SEEGER HOMES INC. - SALES OFFICE

SITE DEVELOPMENT PLANS  
LOT 3, APPALOOSA HIGHWAY 24 SUBDIVISION

**SALES OFFICE**  
**GRADING AND EROSION CONTROL PLAN**

SHEET NO:  
**GP-01**  
DATE:  
05/25/18  
PAGE NO:  
X OF X

SHEET NO:
C-01

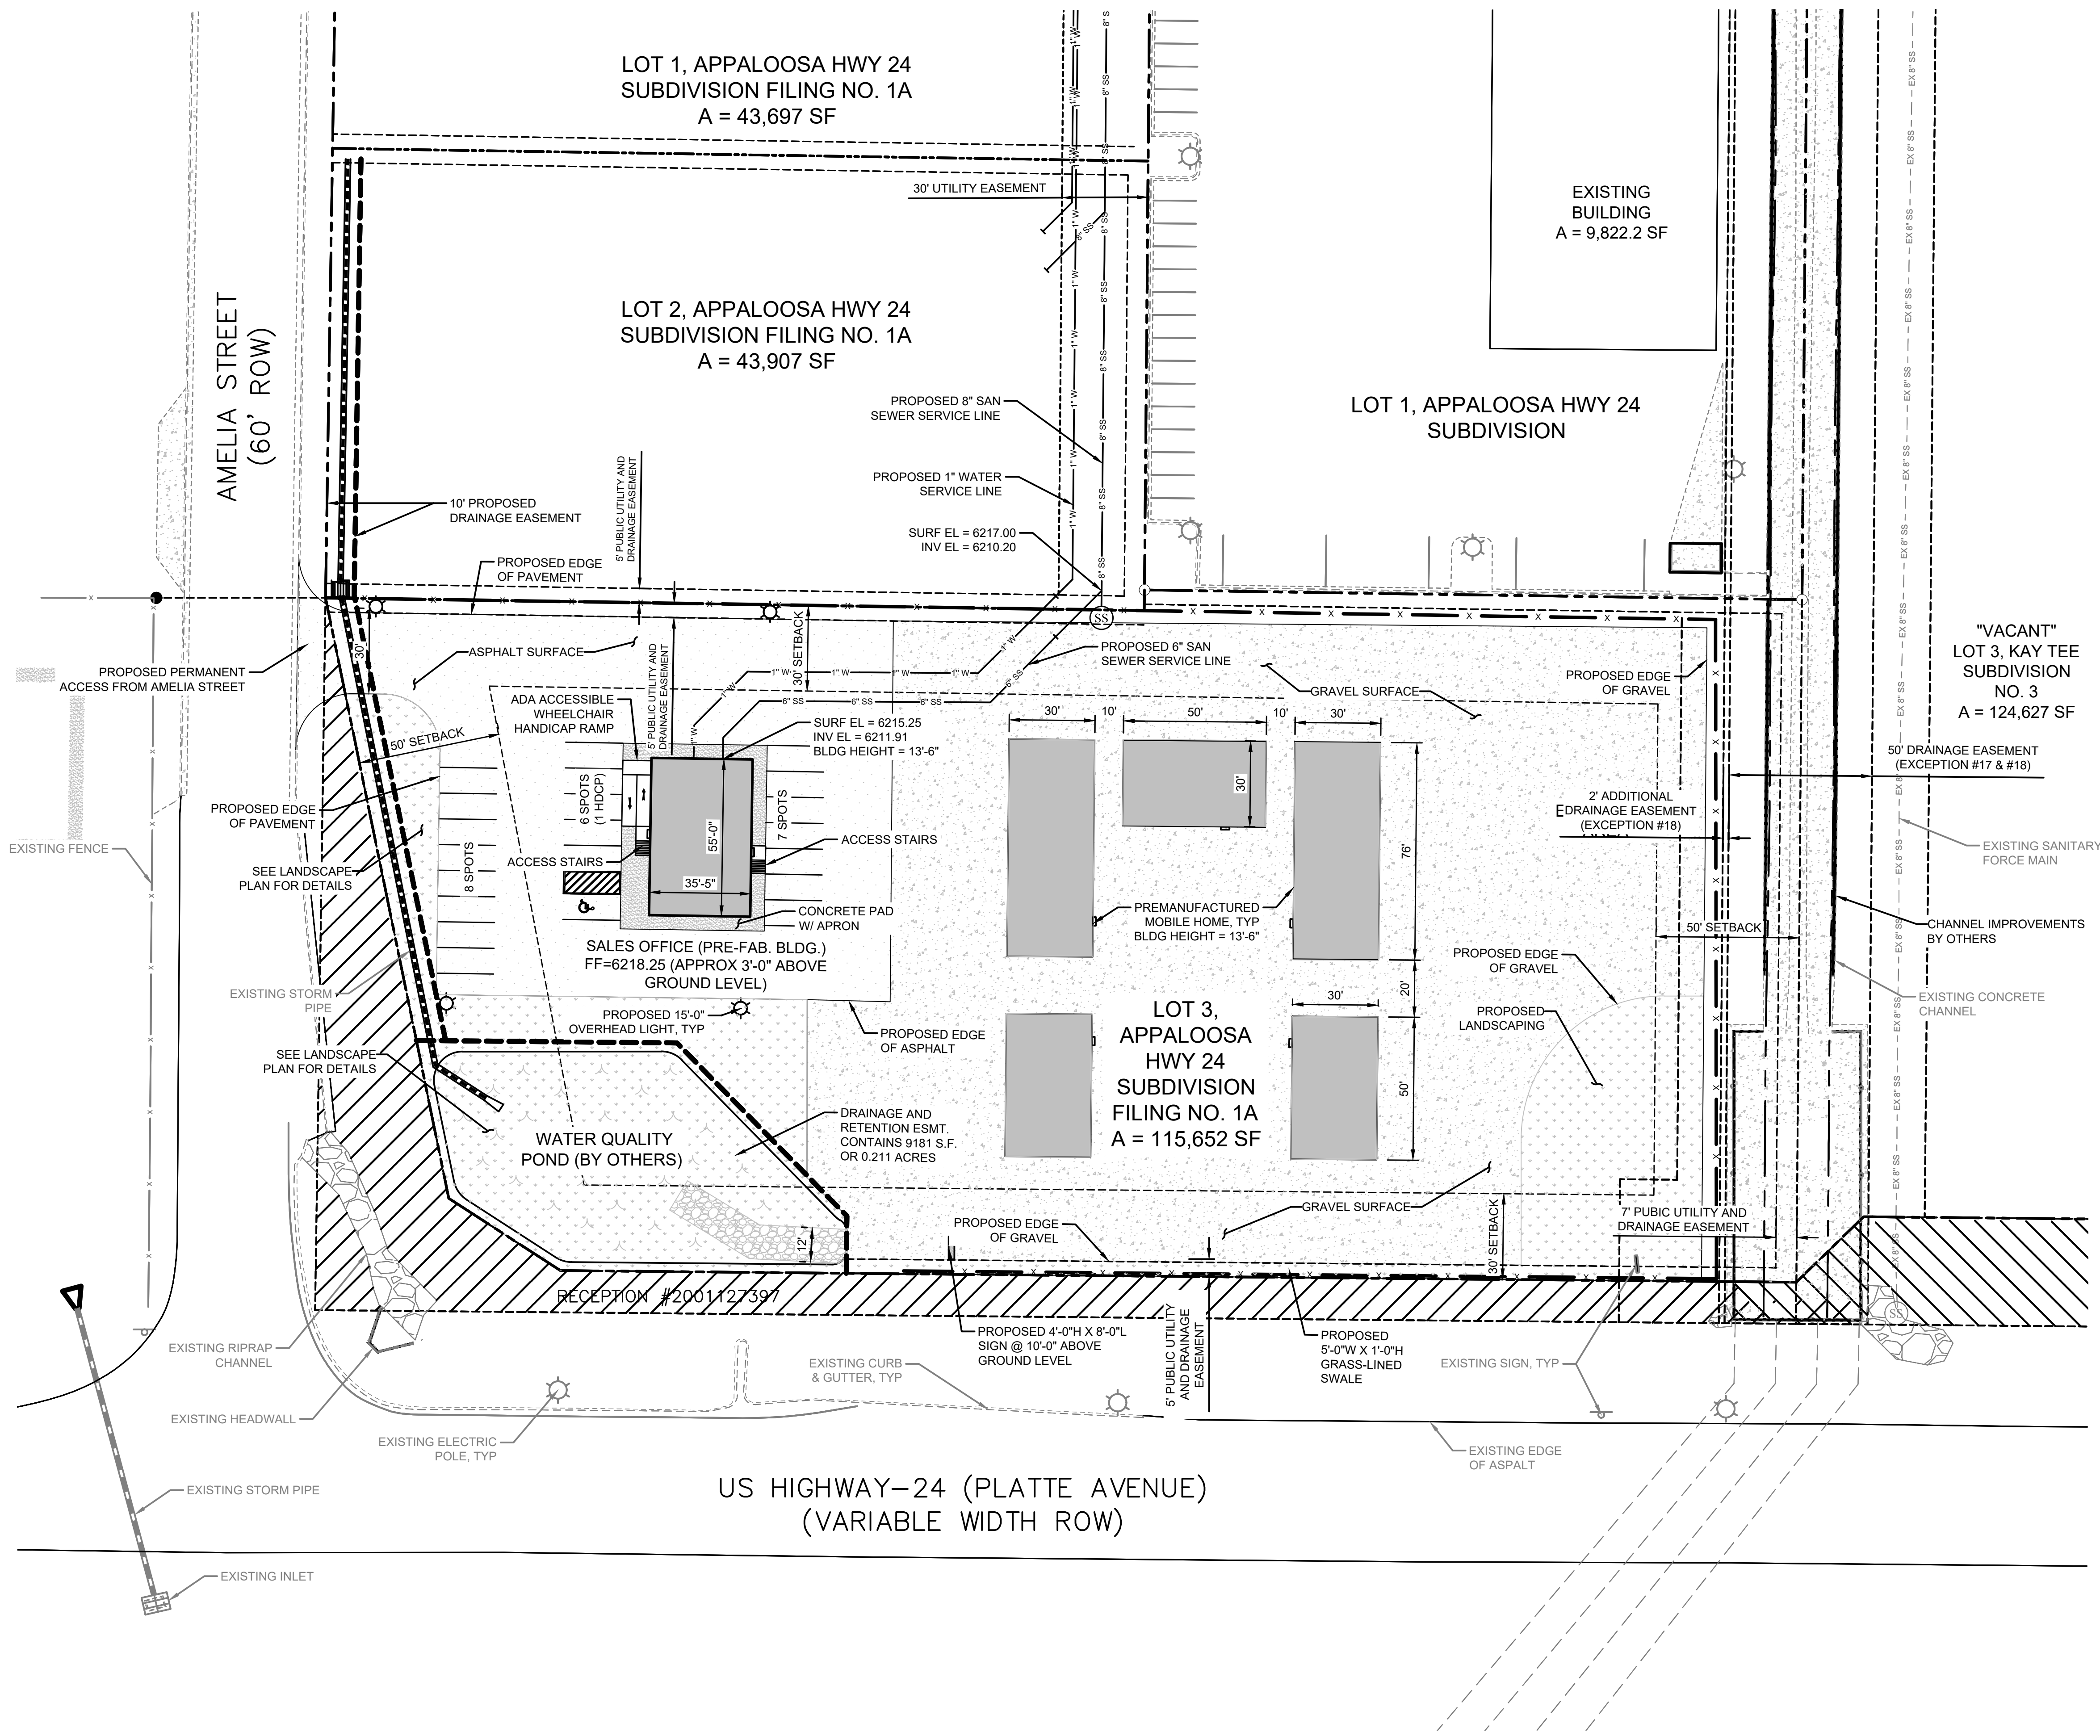
**Subject:** Callout  
**Page Label:** [1] C-01  
**Author:** Daniel Torres  
**Date:** 8/29/2018 2:50:06 PM  
**Color:**

Label FEMA 100yr flood plain

**Subject:** Text Box  
**Page Label:** [1] C-01  
**Author:** Daniel Torres  
**Date:** 8/29/2018 2:54:02 PM  
**Color:**

Add Vicinity Map

**Subject:** Text Box  
**Page Label:** [1] C-01  
**Author:** Daniel Torres  
**Date:** 8/29/2018 3:21:45 PM  
**Color:**

- ☐ Show all existing and proposed easements (permanent and construction)
- ☐ Show existing and proposed storm drainage facilities
- ☐ Submit geotechnical investigation from soil engineer

**Subject:** Text Box  
**Page Label:** [1] C-01  
**Author:** Daniel Torres  
**Date:** 8/29/2018 3:23:12 PM  
**Color:**

Add Standard notes for El Paso County Grading and Erosion Control Plan and add Standard Signature Blocks for El Paso County, Design Engineer, and Owner Statement.

**Subject:** Text Box  
**Page Label:** [1] C-01  
**Author:** Daniel Torres  
**Date:** 8/29/2018 3:27:00 PM  
**Color:**

Add PCD File No. PPR1831

**Subject:** Text Box  
**Page Label:** [1] C-01  
**Author:** Daniel Torres  
**Date:** 9/4/2018 4:14:12 PM  
**Color:**

100% of the area that is gravel or pavement must flow to the water quality facility.

**Subject:** Engineer  
**Page Label:** [1] C-01  
**Author:** dsdgrimm  
**Date:** 8/29/2018 2:39:29 PM  
**Color:** ■

Provide standards details for all construction BMPs used.

**Subject:** Engineer  
**Page Label:** [1] C-01  
**Author:** dsdgrimm  
**Date:** 8/30/2018 7:24:57 AM  
**Color:** ■

Identify the limits of construction, limits of disturbance, property boundary, existing and proposed contours, curb and gutter, etc.

**Subject:** Engineer  
**Page Label:** [1] C-01  
**Author:** dsdgrimm  
**Date:** 9/4/2018 3:28:15 PM  
**Color:** ■

Show the proposed swale per the ADP report.

**Subject:** Engineer  
**Page Label:** [1] C-01  
**Author:** dsdgrimm  
**Date:** 9/4/2018 3:30:36 PM  
**Color:** ■

A complete review has not been done because a SWMP was not submitted. Please see attached checklist. Note: if the item on the checklist is not applicable you must add a note (on this plan or on the SWMP) that states why, N/A on the checklist is not acceptable.

**Subject:** Engineer  
**Page Label:** [1] C-01  
**Author:** dsdgrimm  
**Date:** 9/4/2018 3:31:19 PM  
**Color:** ■

Identify all adjacent property owners or subdivision names.

**Subject:** Engineer  
**Page Label:** [1] C-01  
**Author:** dsdgrimm  
**Date:** 9/4/2018 3:34:04 PM  
**Color:** ■

Provide flow arrows for the site.
